# **OXFORDSHIRE COUNTY COUNCIL'S RESPONSE TO CONSULTATION ON THE FOLLOWING DEVELOPMENT PROPOSAL**

**Application no:** 16/01267/REM

**Proposal:** Reserved matters application to 13/00433/OUT - Replan of KMD parcel at Kingsmere

**Location:** KMD South West Bicester Development Site Middleton Stoney Road Bicester

Drawing Title  
**TYPE B AFFORDABLE VERSION 1**

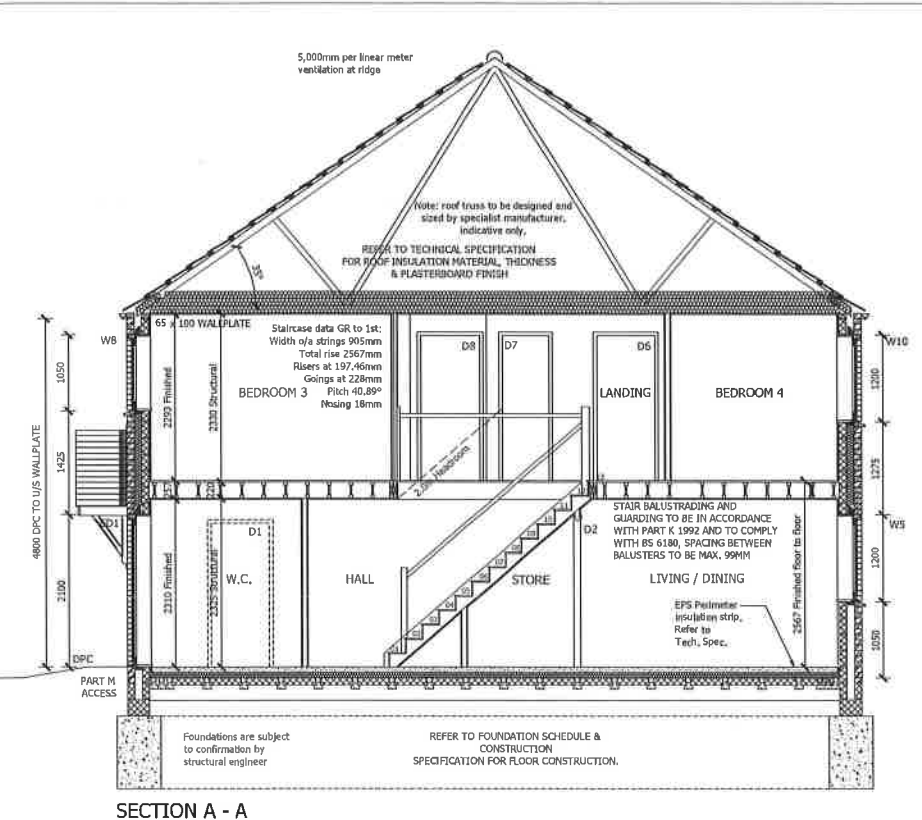
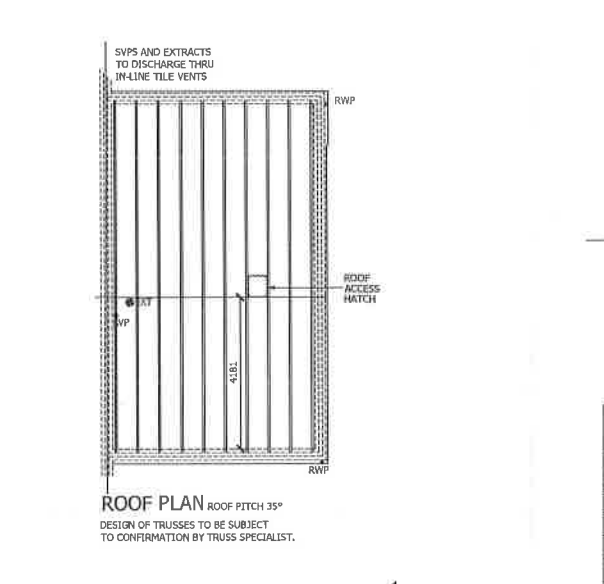
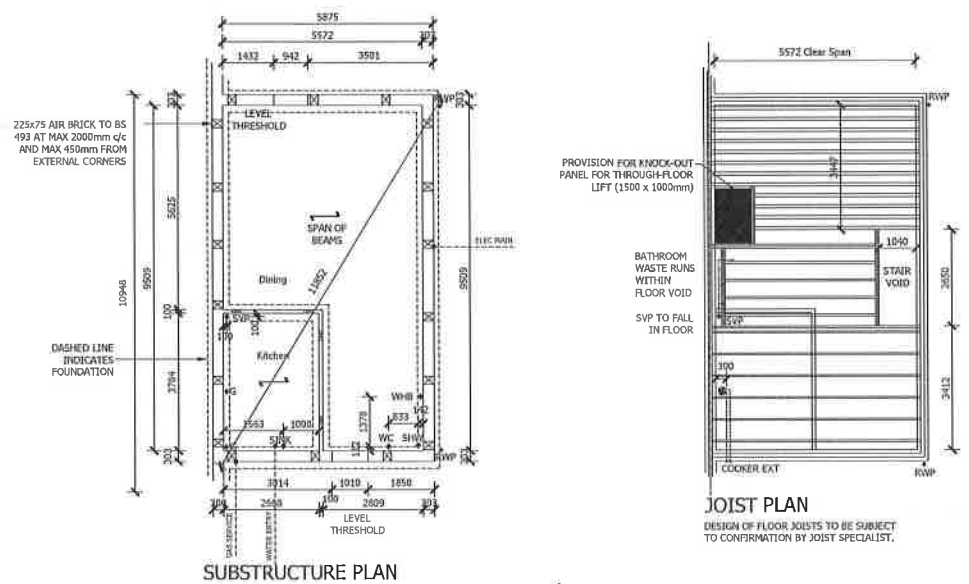
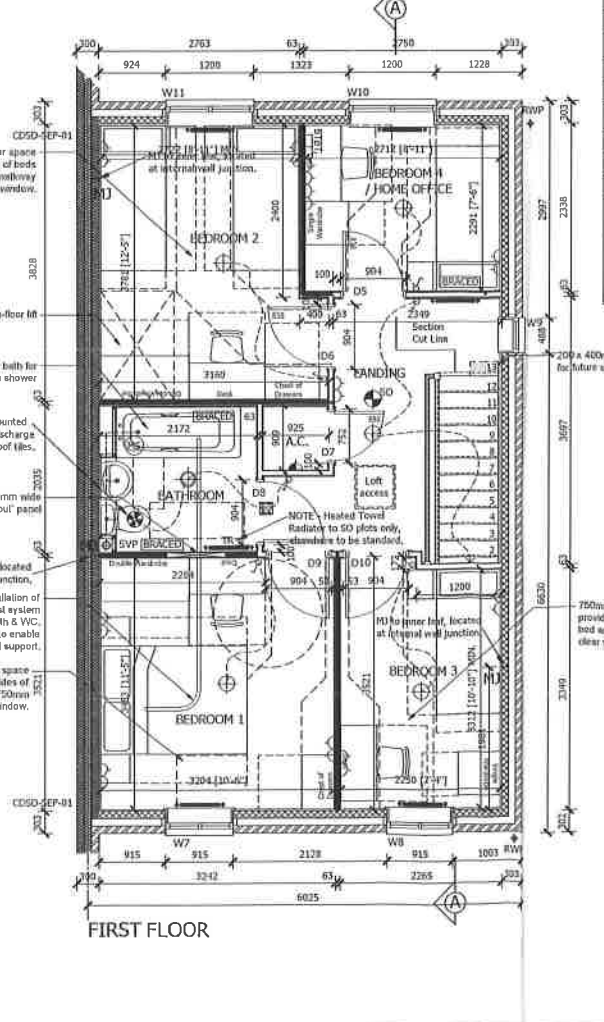
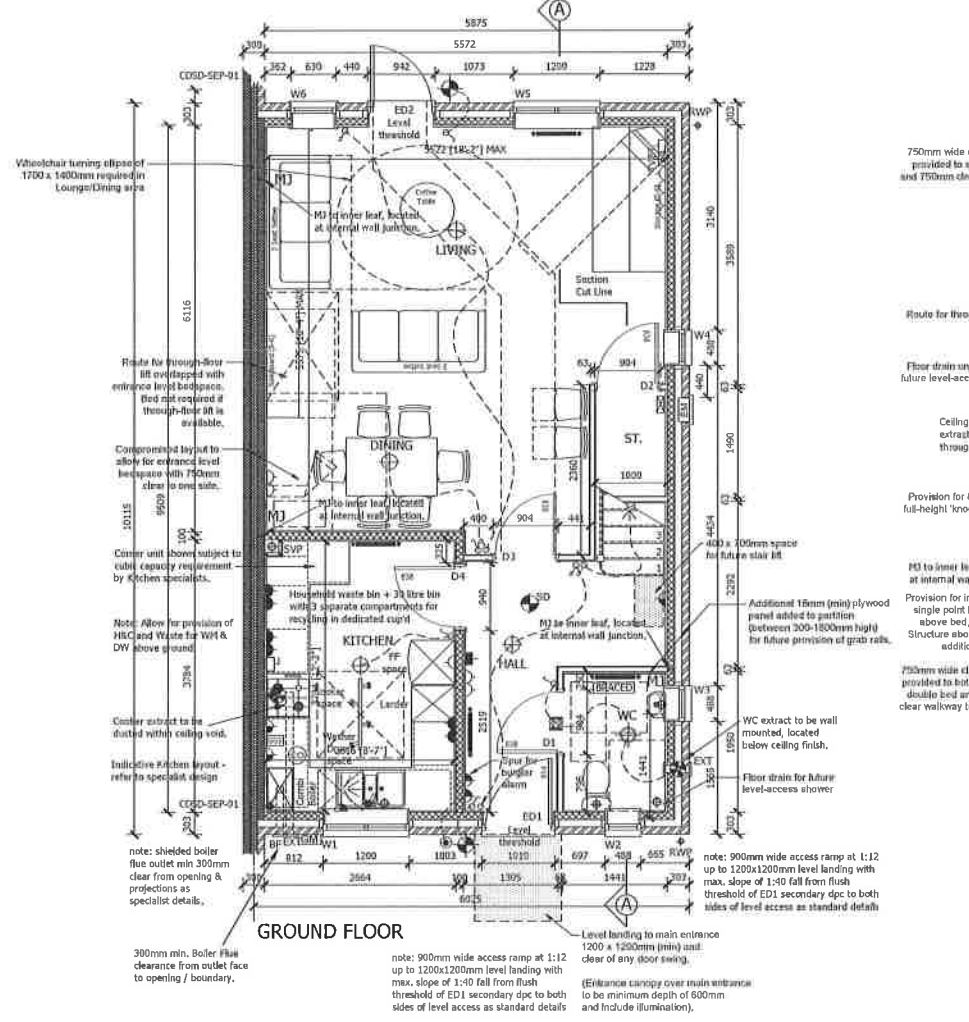
If bicycles are to be stored in garden sheds, all properties that will have back gardens need to have garden gates so that residents can get bicycles and refuse bins from the garden to the highway. The properties within plots 10 and 24 do not appear to have garden gates on the plan submitted. This might be a drafting error and needs to be corrected.

**FRONT ELEVATION**  
PLOTS 17, 18, 19 & 20 - Facing Brick

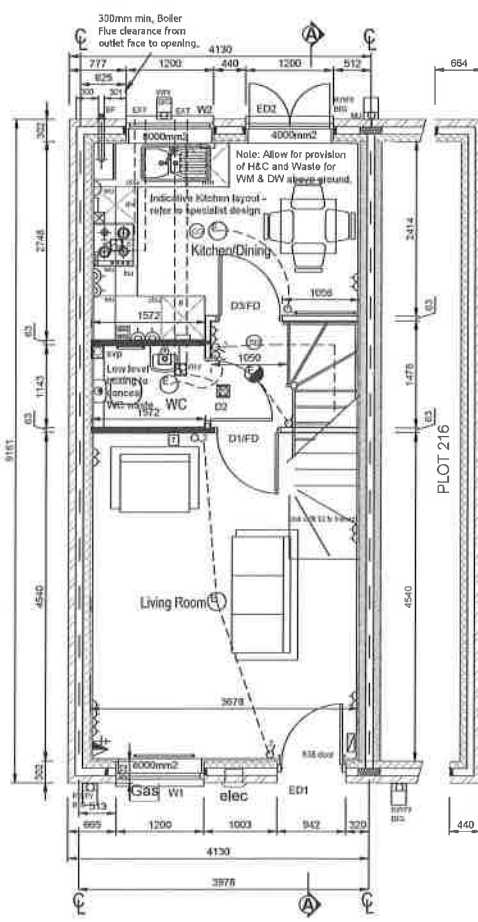
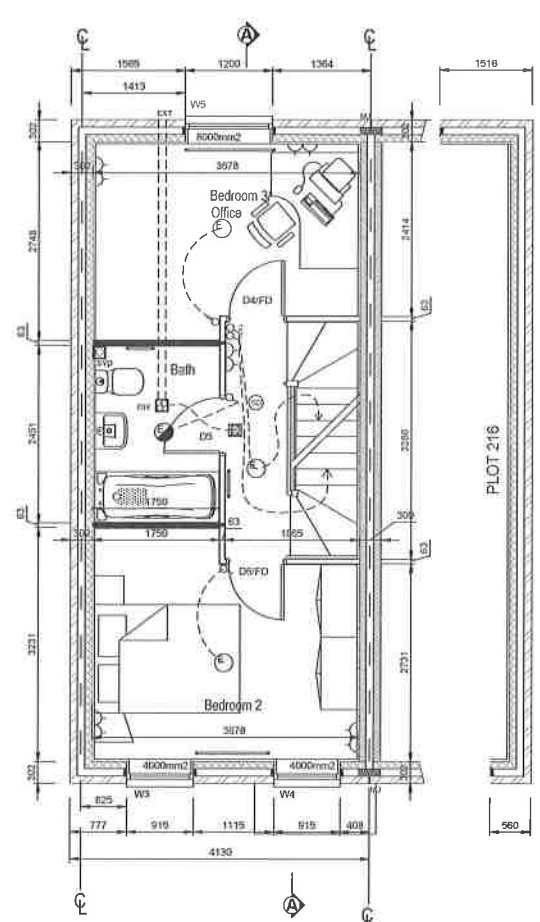
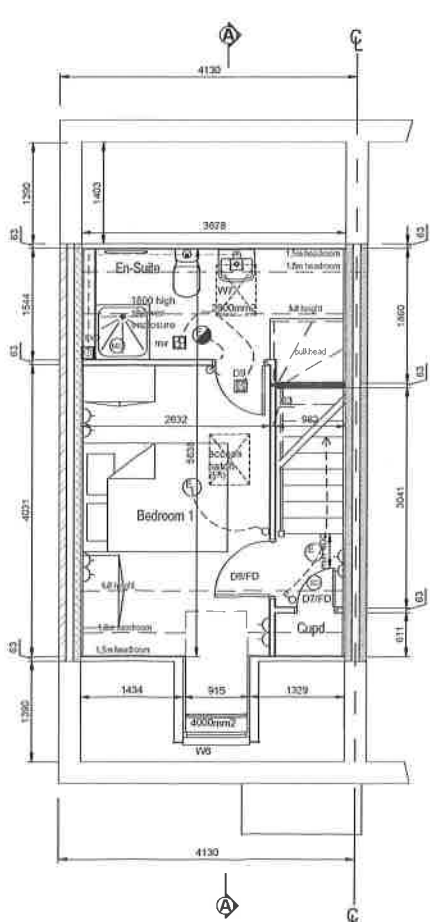
The part of the Kingsmere Design Code that the applicant has submitted with this application appears to say that dwellings of 1-2 bedrooms shall be allocated one off-road parking space each. However, the dwellings within plots 15-20 appear to have been allocated two off-road parking spaces as specified in Cherwell District Council's current residential parking standards which are described in the above-mentioned design guide. Might this lead to residents within the other two-bedroomed properties that are allocated one space, but that might own two cars, being forced to park them on nearby side roads, thereby inhibiting access for service vehicles?
